# CITY OF ALBUQUERQUE

**RE: Smiles for Kids Dental Office – Phase 2**  
**Conceptual Grading and Drainage Plan**  
**Stamp Date: 6/1/17**  
**Hydrology File: C12D055**

Based upon the information provided in your re-submittal received 6/1/2017, the Conceptual Grading and Drainage Plan **is not** approved for Site Plan for Building Permit. The following comments need to be addressed for approval of the above referenced project:

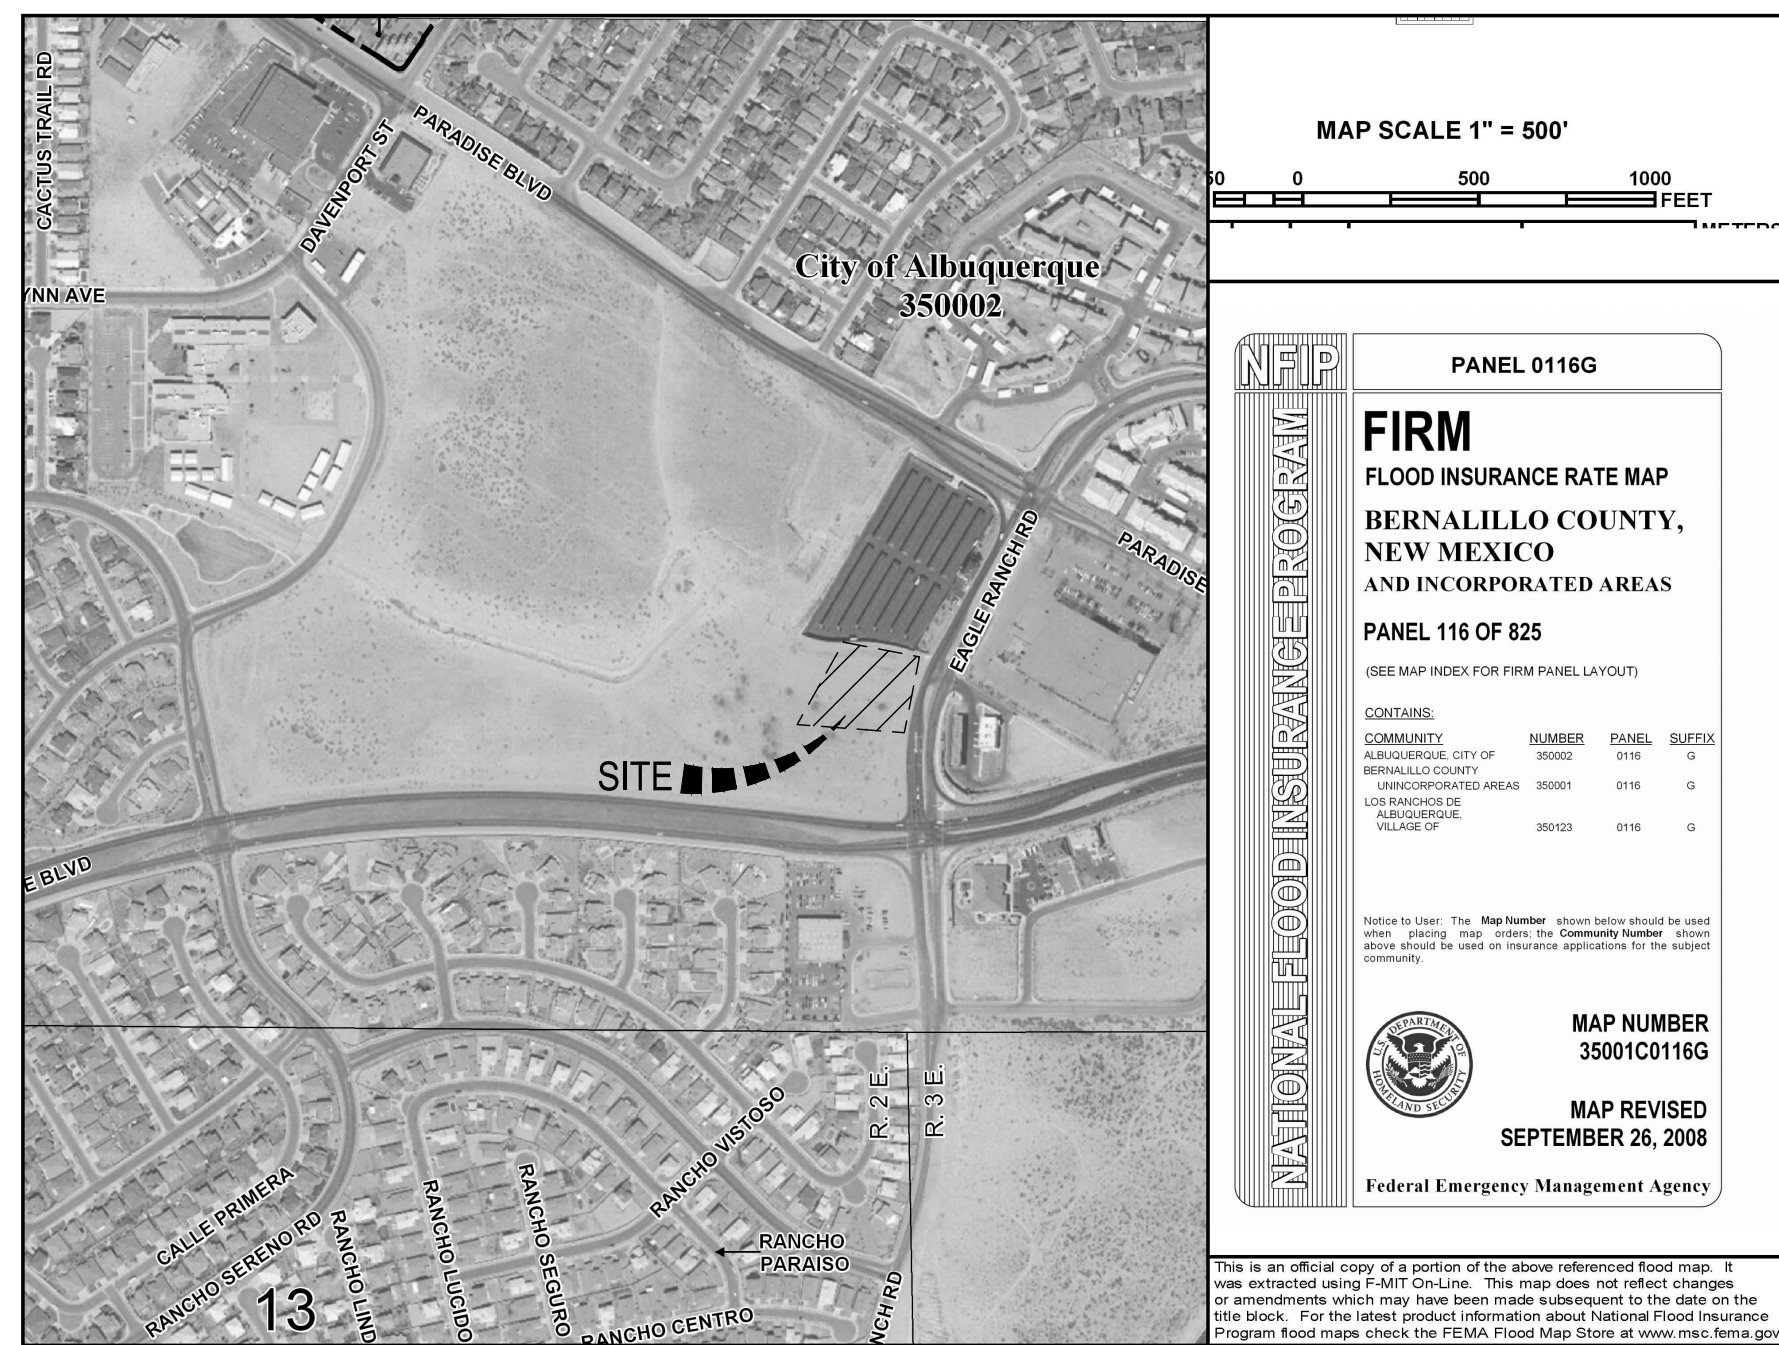
1. Please place a note **“Not for Construction”** on C001, C002, and C100.
2. On Sheet C001. Under the First Flush Calculations, the volume provided shows 1310 CF and the labeled volume of the pond is 1240 CF. Please correct whichever one is incorrect.
3. On Sheet C100. It appears that the proposed bike lane should continue to the corner of Eagle Ranch and Nunzio. This would mean that the pond will have to be shifted over a little bit and the valley cutter across Nunzio Avenue will have to be replaced to reflect the new bike lane. Please get the bike lane layout approved by transportation before resubmitting. Also please do not forget to place the valley gutter on the infrastructure list.
